# CITY OF ALBUQUERQUE

**Re: Estates @ Glendale, Lots 1 & 2,**  
**Grading Plan for Pad Certification—Accepted**  
**Engineer's Stamp date 07-13-12 (B19/D027)**  
**Certification date 10-09-12**

Drawing file: B19D027 / unapproved grading plan-showing sw-culvert.pdf

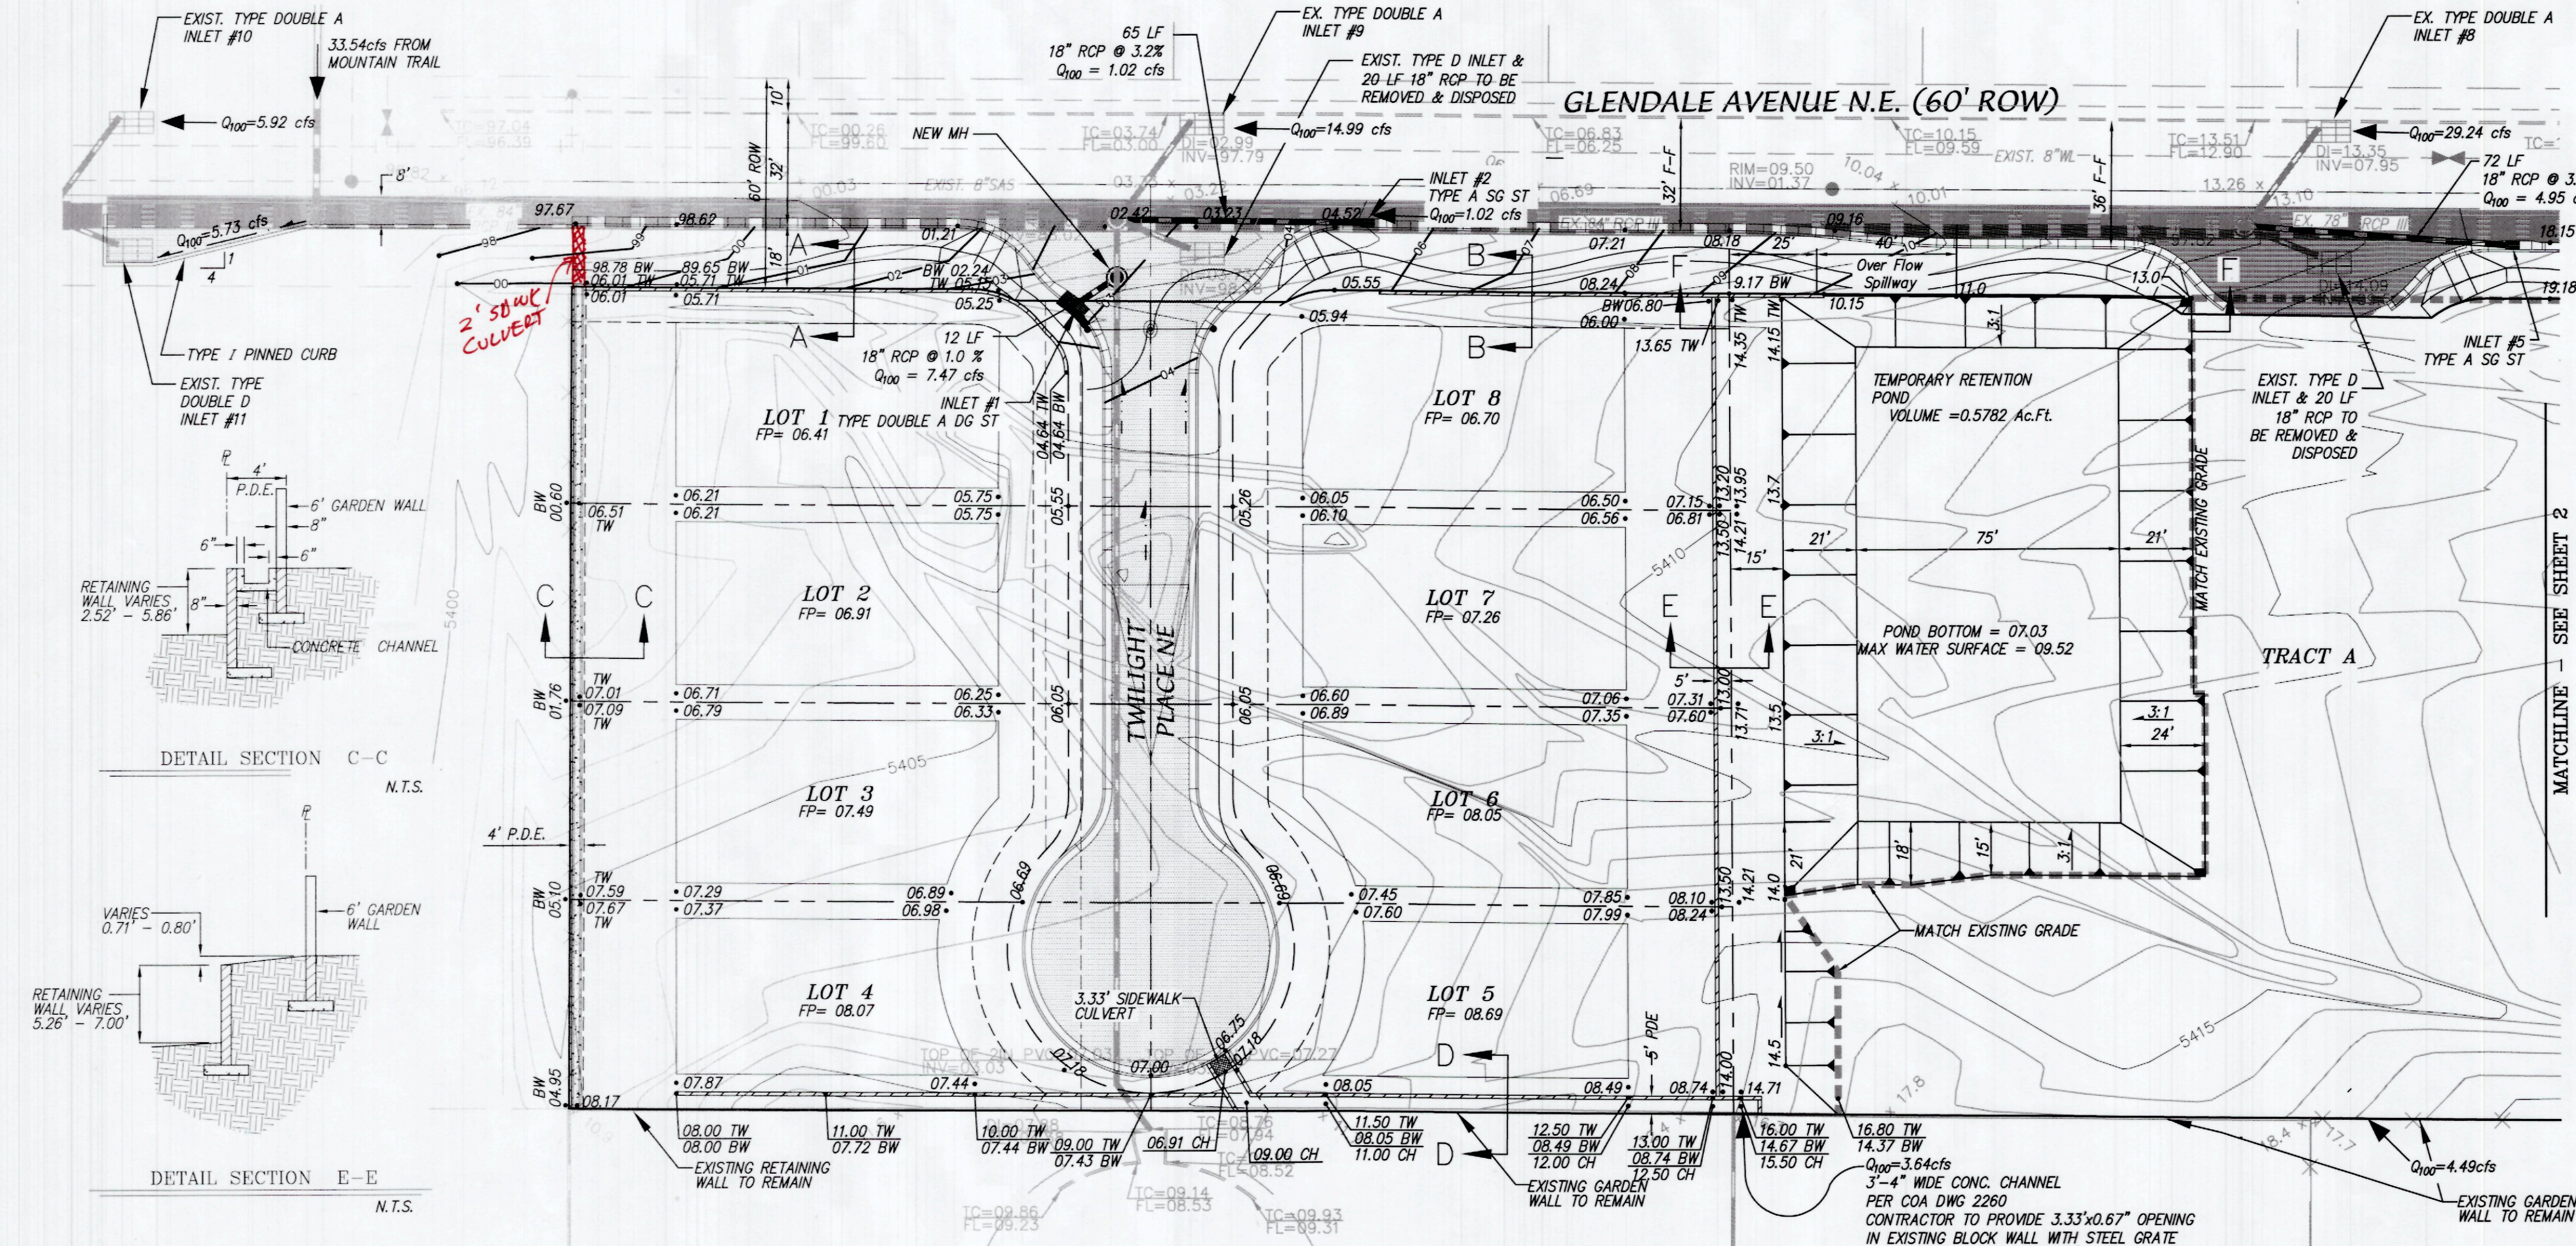
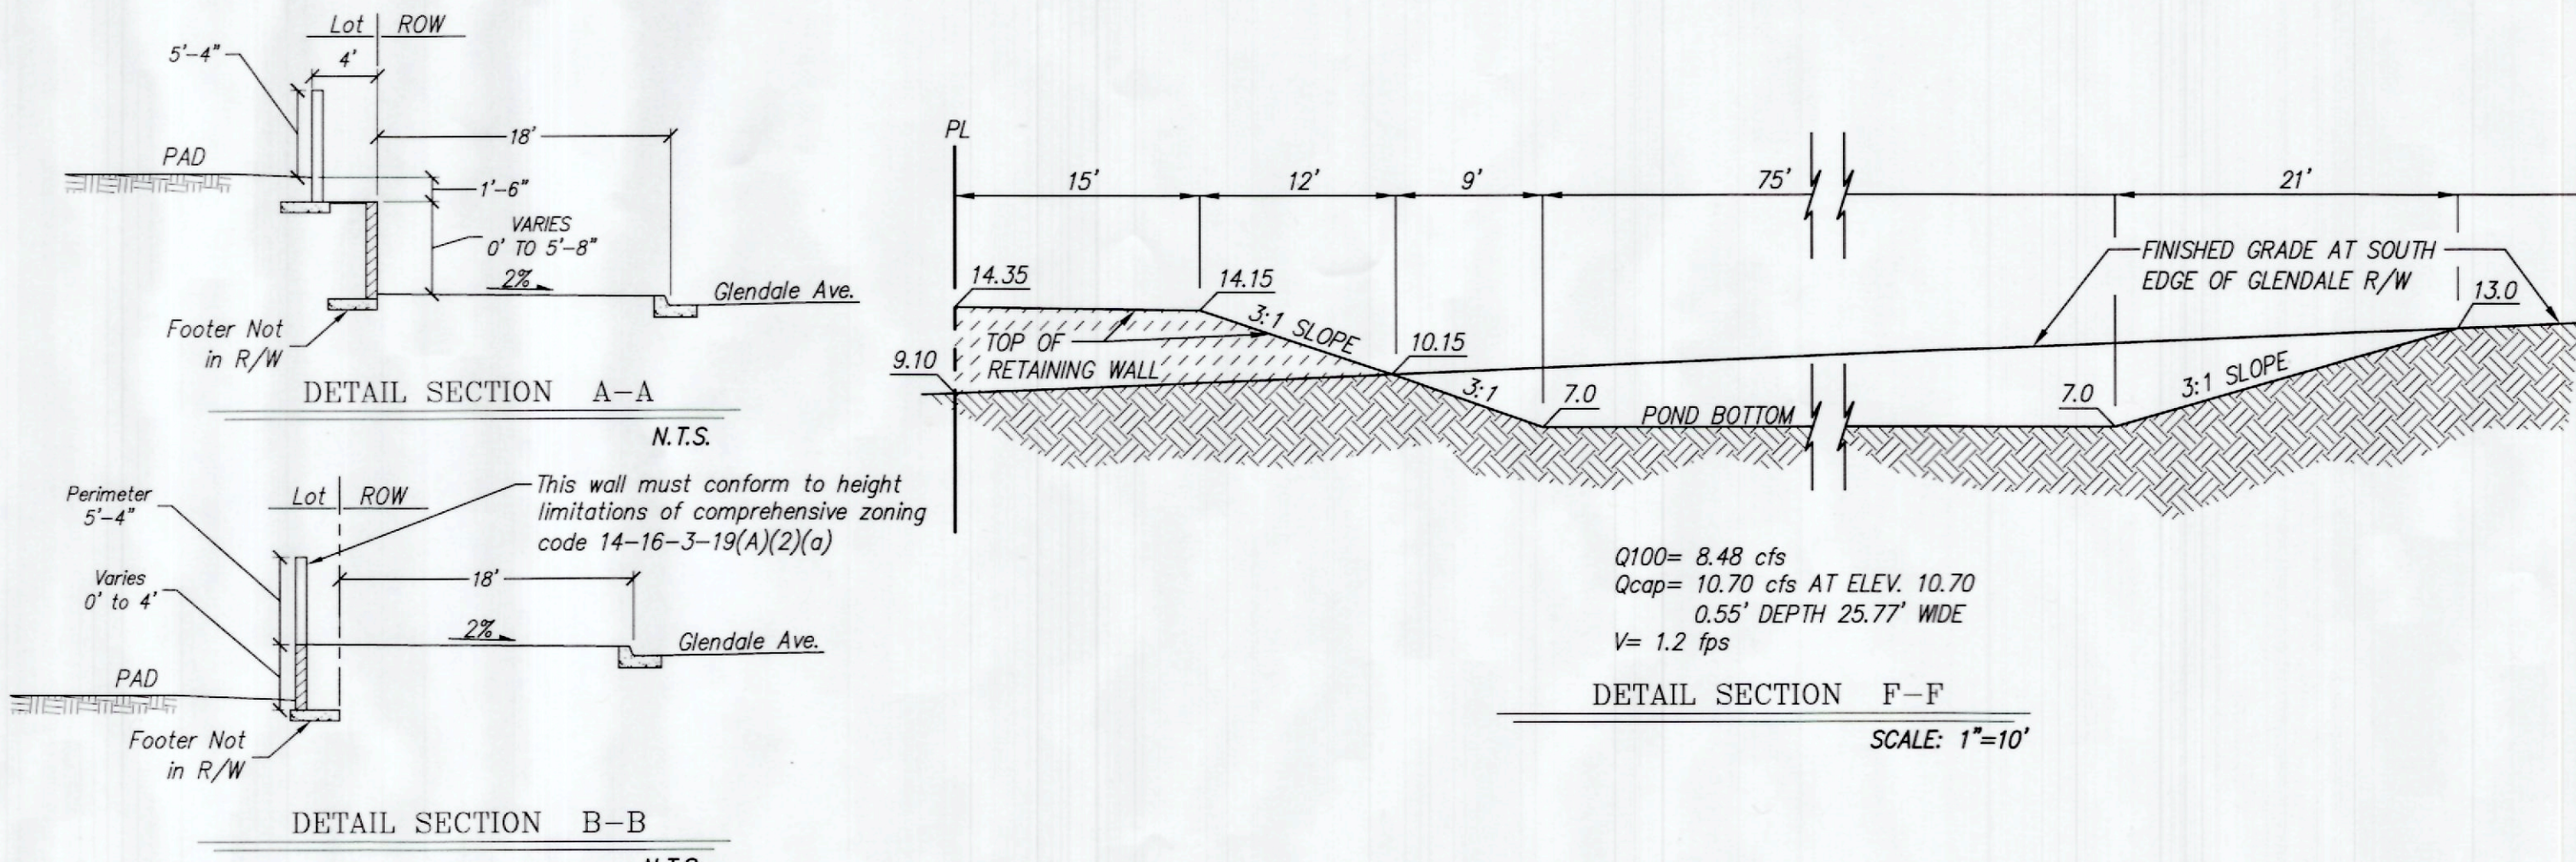
1. The curb along the south side of Glendale, from the west property line to the inlet, will need completion.
2. Completion on the retaining wall at the south end of Twilight Lane requires completion.
3. Twilight will require asphalt pavement.
4. Please certify the pond volume.
